FOSSE GREEN ENERGY DEVELOPMENT CONSENT ORDER

PINS REFERENCE EN010154

**DEADLINE 5: NATIONAL HIGHWAYS'
COMMENTS ON SUBMISSIONS MADE BY THE
APPLICANT AT DEADLINE 4**

1.1 This is a written submission made on behalf of National Highways in response to the Applicant's deadline 4 response (REP4-018) to National Highways deadline 3 and 3A submissions

Figure 3-8

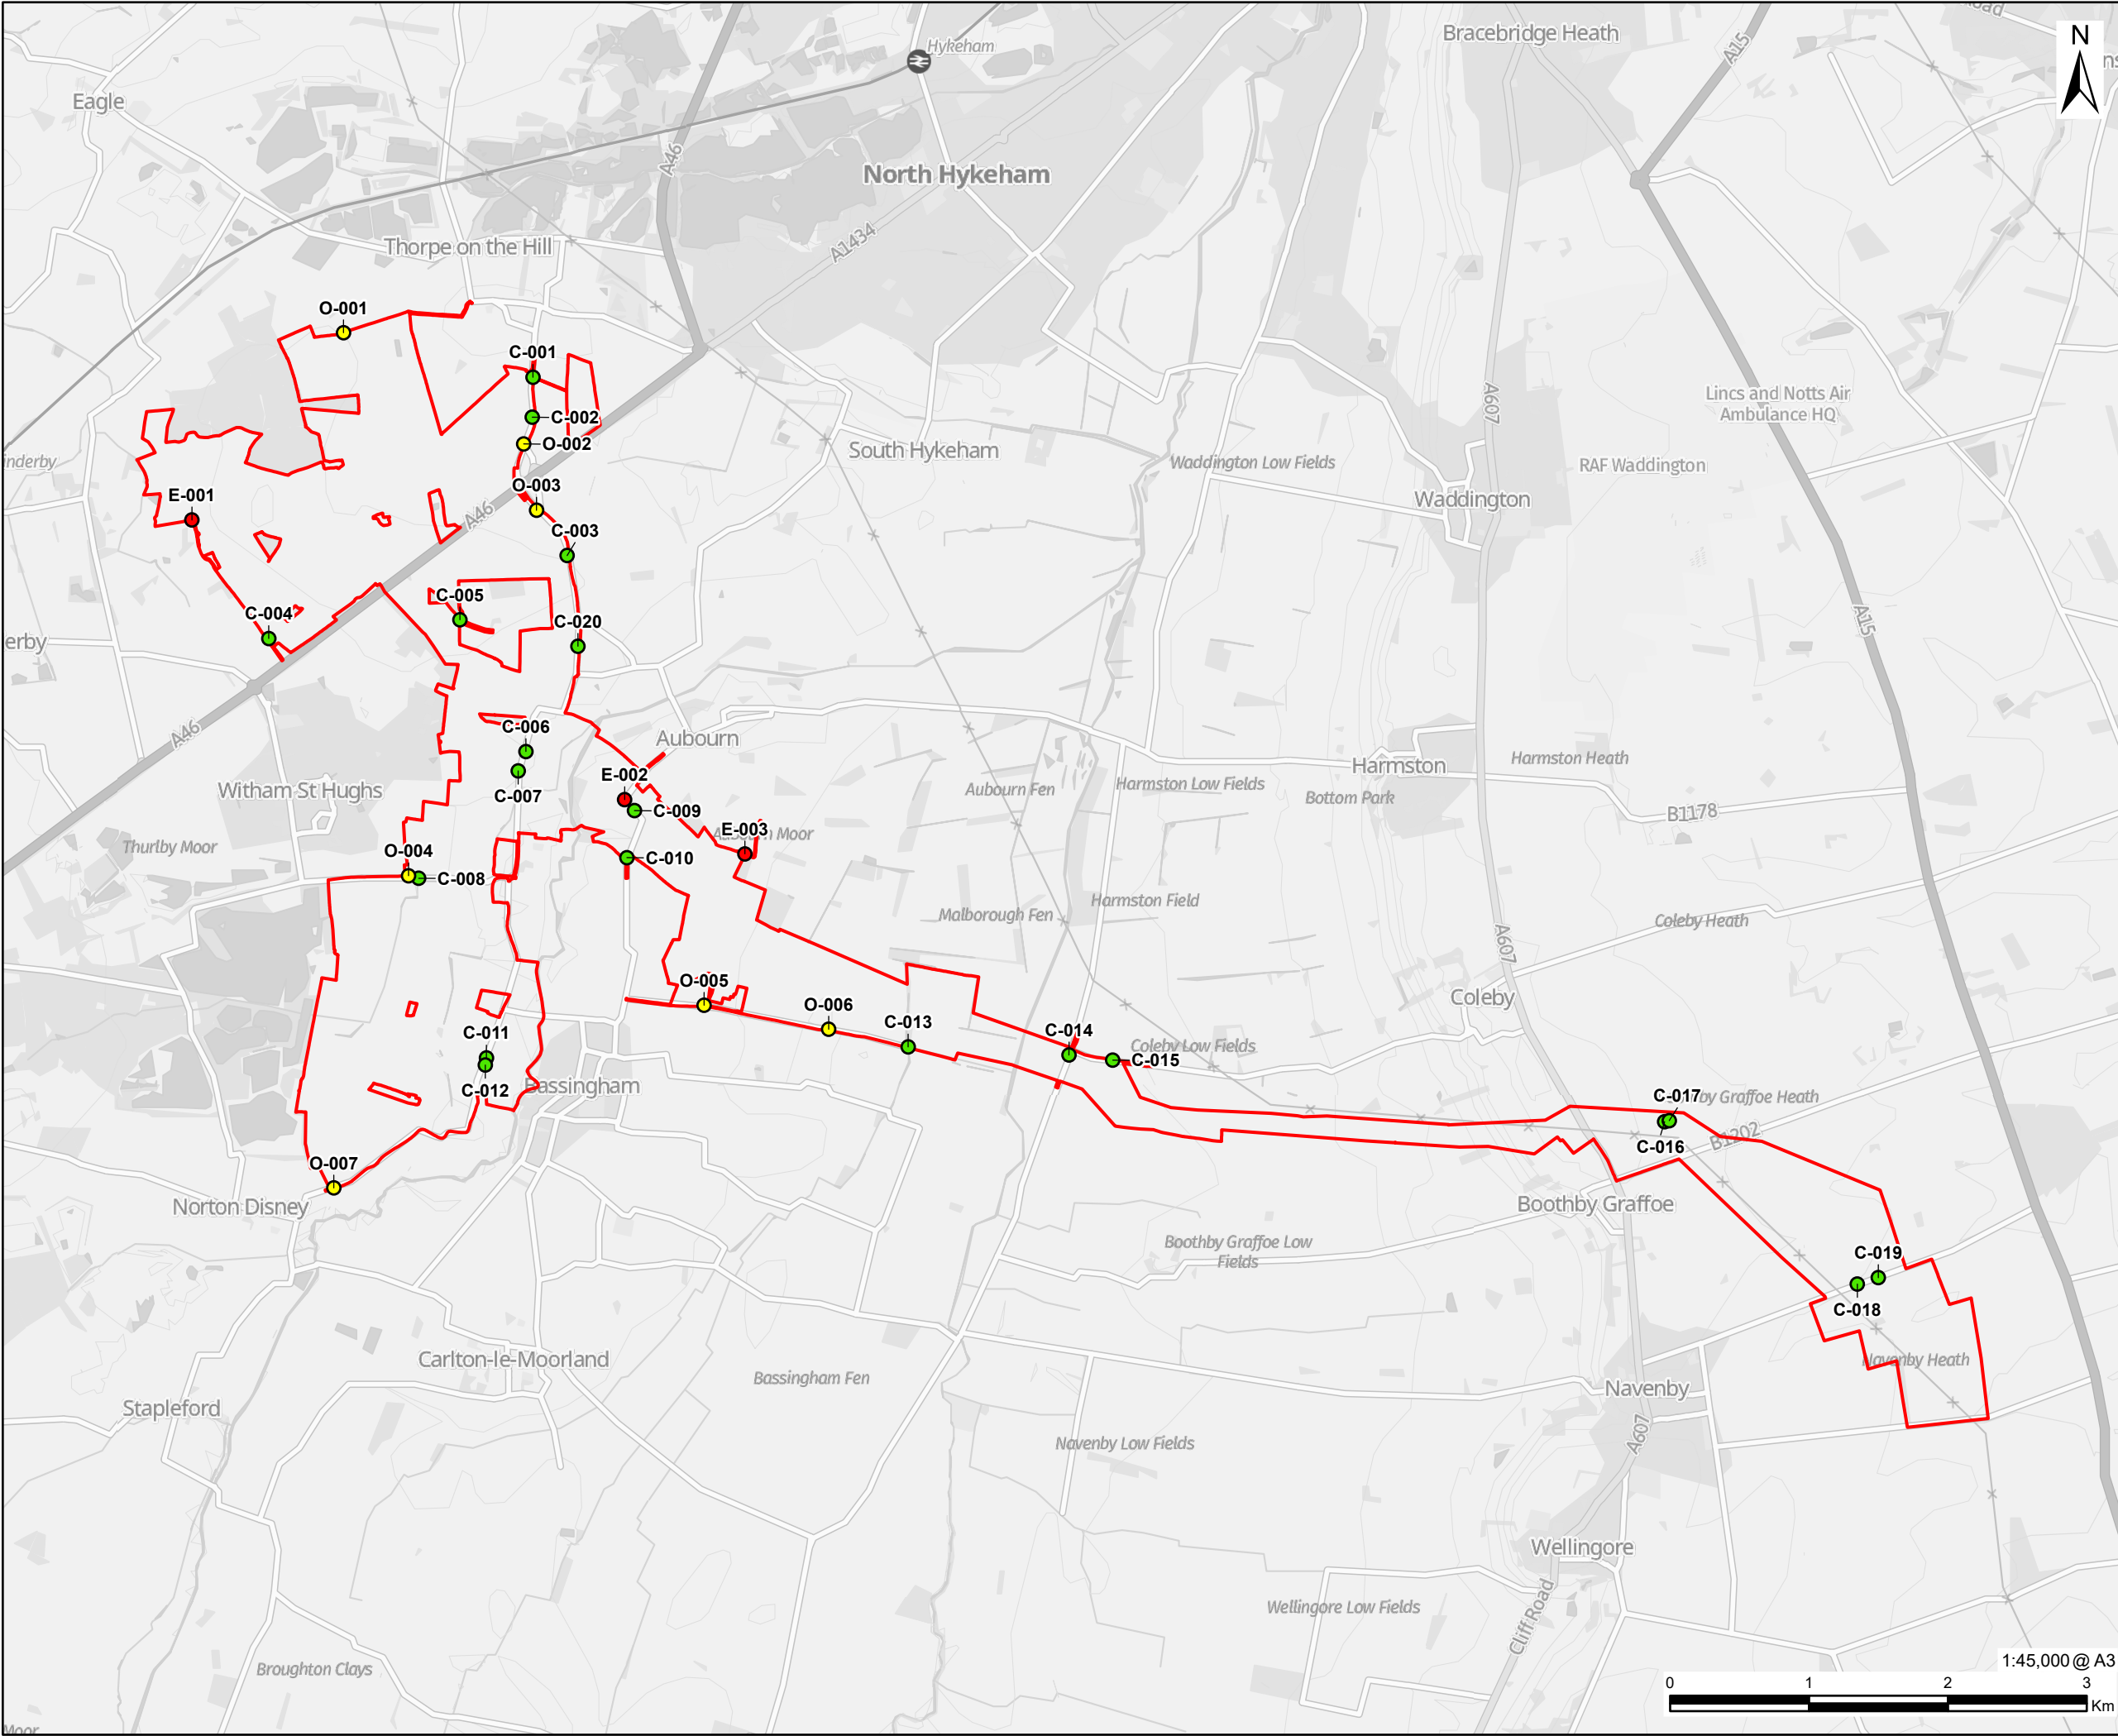
<p>In the Applicant's response, concern is raised that the involvement of more than one discharging authority in respect of the CTMP may cause delay. National Highways notes that multiple discharging authorities have been provided for previously, and that Schedule 2, Part 2 of The Viking CCS Carbon Dioxide Pipeline Order 2025 contains drafting which expressly addressed scenarios where more than one discharging authority was involved. Similar drafting could be adopted here if considered necessary</p>
<p>b) National Highways considers the wording adequate. Not every AIL movement will require a road condition survey, as the applicant has outlined. This will be determined on a case by-case basis, depending on current road conditions, any existing concerns regarding the roads used in the route, or if the applicant wishes to ensure they can demonstrate no damage has occurred during the AIL movement. When a formal Special-Order application (abnormal load that exceeds the limits set out the Special Types General Order (STGO) is received we will consult the relevant road owners. The road and structure owners will then advise whether they require pre- and post-movement inspections, and this will be included as a condition of the move within the permit and agreed route. For the heavier loads this is common, but at this stage it is too early to for definite whether this would be needed. For further information please see annexed notification requirements for the movement of Abnormal Indivisible Loads.</p>	<p>Whilst the Applicant acknowledges National Highways response, as set out in the Applicant's Response to the Examining Authority's Second Written Questions [REP3-045] (ref. TT.2.05), paragraph 7.3.4 of the Framework CTMP [REP3-032] has been updated (submitted to the Examination at Deadline 3) to note: "<i>In addition, a separate road condition survey may will be carried out for the abnormal vehicle routes (transformer and cable drums) for the transformer to the Principal Site, covering the route between the A46 junction and the proposed site access on Bassingham Road (C-009) i.e. via Haddington Lane.</i>" This update ensures that a road condition survey will be carried out for the AIL route, for both the AIL for the transformer and also the other (cable drum) AIL routes, between the A46 junction and the proposed site access on Bassingham Road (C-009).</p>	<p>National Highways considers this wording acceptable.</p>
